**REQUEST**

Current Zoning: R-3 (single family residential)  
Proposed Zoning: R-12MF(CD) (multifamily residential, conditional)

Approximately 9.96 acres located on the east side of Steele Creek Road and south of Erwin Road.

The petition proposes to rezone a property currently occupied by one single family home to R-12MF(CD) to allow the development of a 119 unit senior independent living community at a density of 11.95 dwelling units per acre.

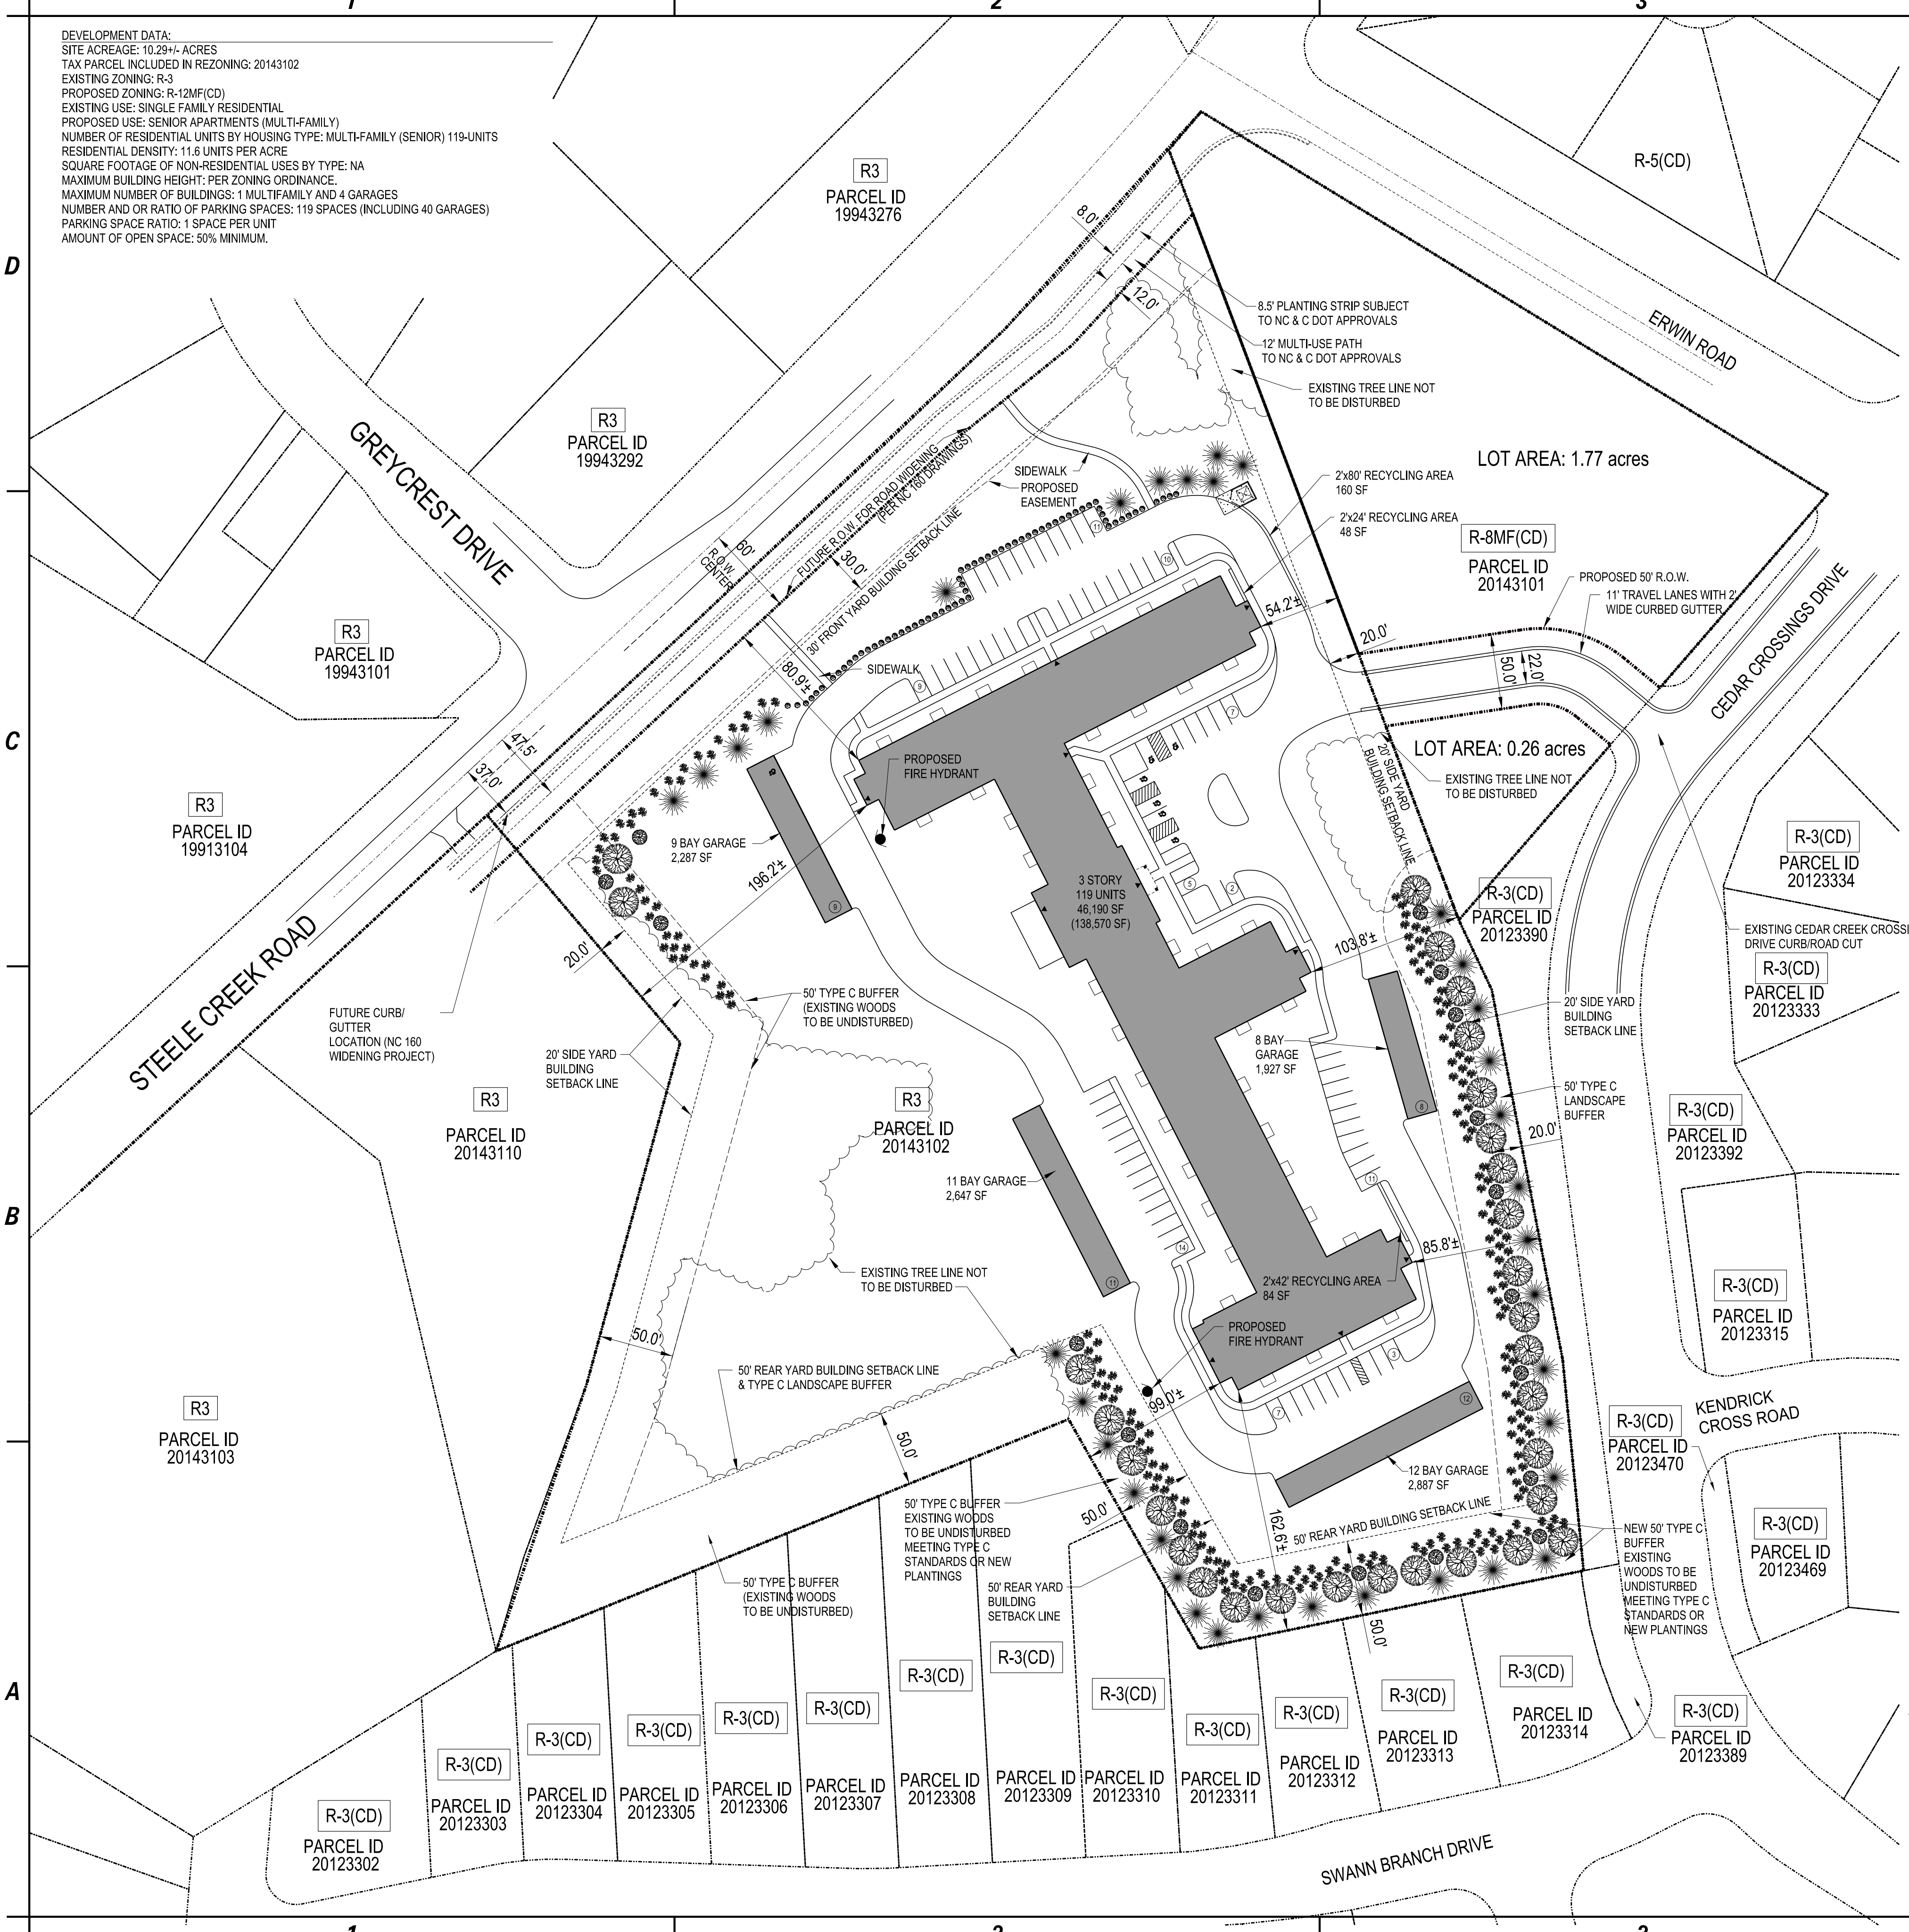
**A new site plan with access off of Cedar Crossings was provided on 08-17-2020, requiring a substantial review.** This site plan needs revision to address updated comments, outstanding comments, and new comments based off of the new site plan. These include labeling and dimensioning a right-turn lane. Please note that all CDOT reviews have included a comment to add a left-turn lane onto Erwin Rd to help ease congestion in the area, however, this is not a requirement for approval and has not been agreed to by the petitioner.

- ~~1. The petitioner should revise the site plan and conditional note (Section Transportation.7.) to commit to a north eastbound 100' right turn lane into the from NC 160 into Erwin Drive. Please clearly label and dimension the right turn lane.  
Updated Comment from 09-14-2020 Site Plan: It appears this right turn lane is there, however, it is not labeled nor dimensioned. **Addressed**~~

- ~~2. The petitioner should revise the site plan and conditional note (Section Transportation.7.) to commit to construct a south westbound left turn lane with 150' of storage and appropriate left turn lane tapers based on the speed limit from NC 160 into Erwin Drive.  
Updated Comment with 09-14-2020 Site Plan: This left turn lane has been requested during every previous review phase and in multiple resubmittal meetings. Both NCDOT and CDOT cannot require this left turn lane and, as a result, the petitioner has opted to not include this left turn lane in their site plan and scope of work. This note is not meant to deter approval of this petition, rather, this note serves to provide transparency of information from previous reviews and discussions between all parties. **Addressed**~~

- ~~3. Include language in the notes that validation of this easement will be provided to CDOT before final permitting. **Addressed**~~

- ~~4. Site is still not showing enough protected tree save. Tree save is required to be 15% of total area made up of existing trees. Replanted tree save is not an option for this site. **Addressed**~~
